From:
Sent: 21 September 2023 16:13
To: DCAdmin
Subject: Emley planning objections

Comments in relation to the following applications by Newett Homes;

2023/92255 Land at Green Acres Close, Emley, Variation of Conditions 1 (Plans) , 2 (Crime Prevention) and 15 (Permitted Development) of Previous reserved matters approval 2021/93286 pursuant to outline permission 2020/91215

And
2023/92327 Land at Green Acres Close – modified plans for 6 Dwellings plus parking and landscaping and modified plans for ball stop netting.

Project		Residential Development of Wentworth Drive, Emley	
Client		Barratt Homes	
Drawing		Section 104 Layout	
Drawn By:	TM	Date:	05/01/2022
Checked:	GS	Scale:	1:250
Drawing No:	AMA/21311/D/500	Rev:	P6

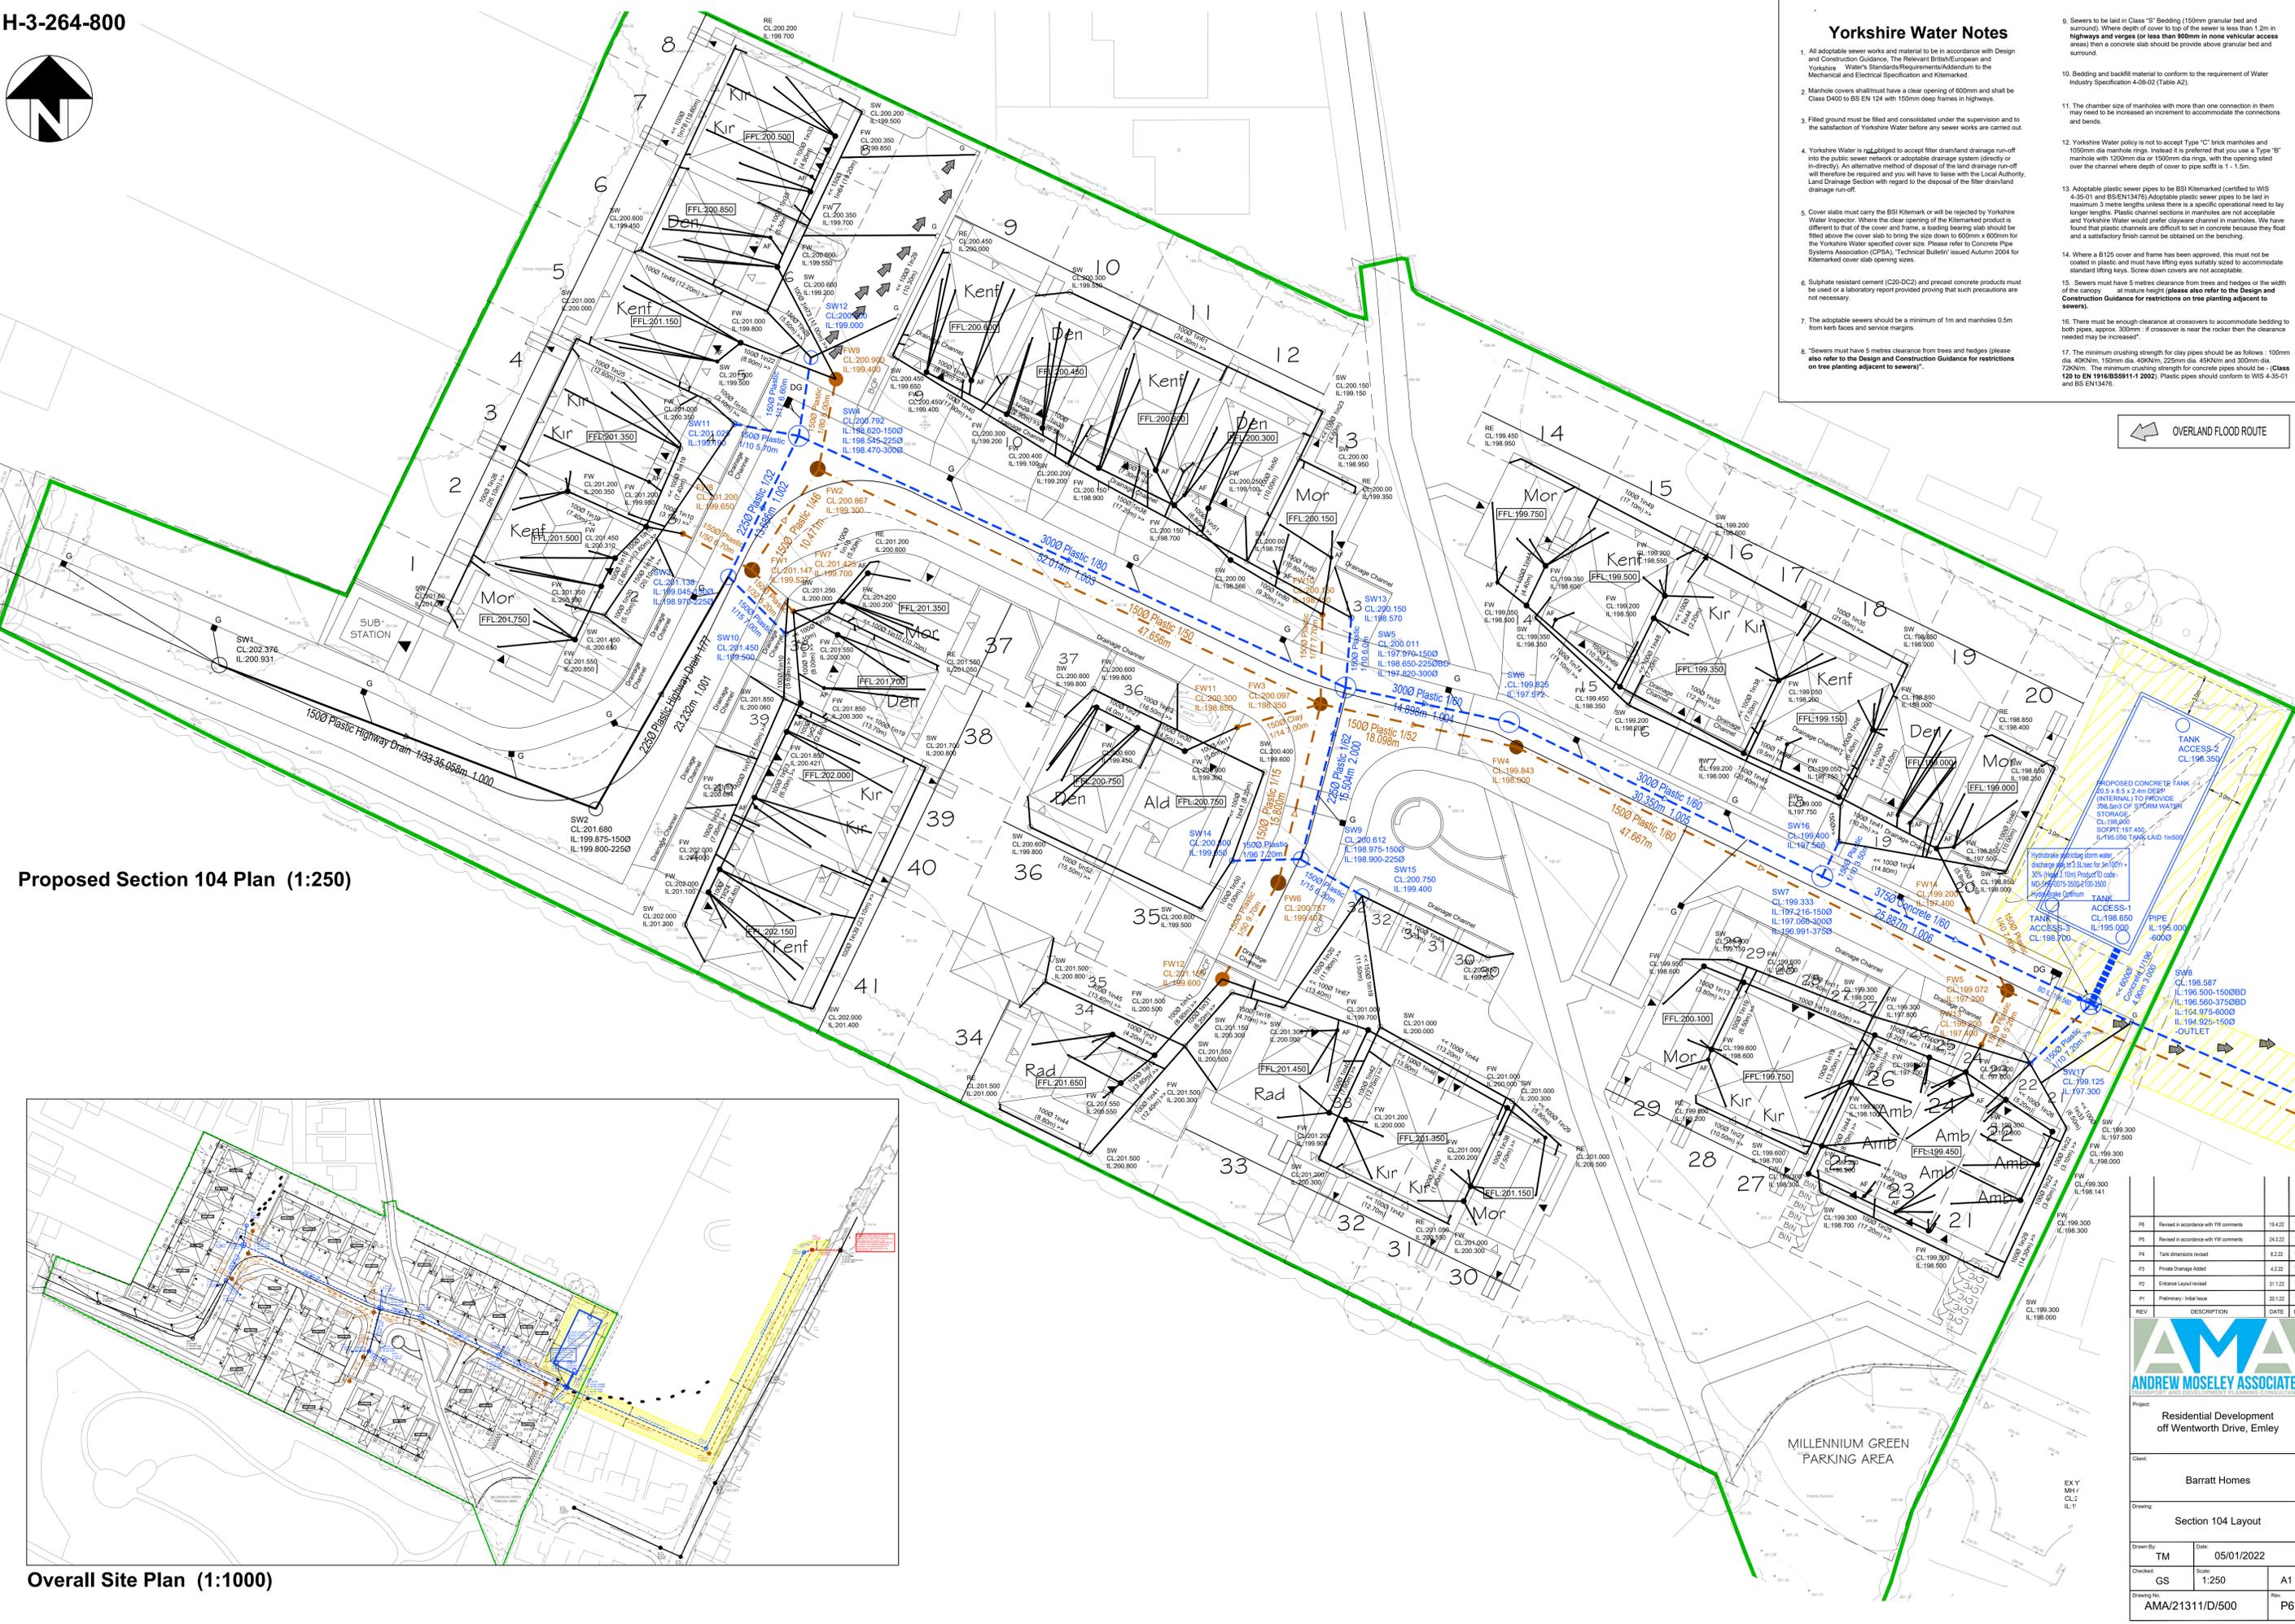
Newett Homes have submitted plans for temporary drainage that will affect the parking area and entrance to the Emley Millennium Green – Any drainage plans that affect the parking area or entrance must be discussed and agreed with the Trustees of the Green and must not block or impede the area at any time.
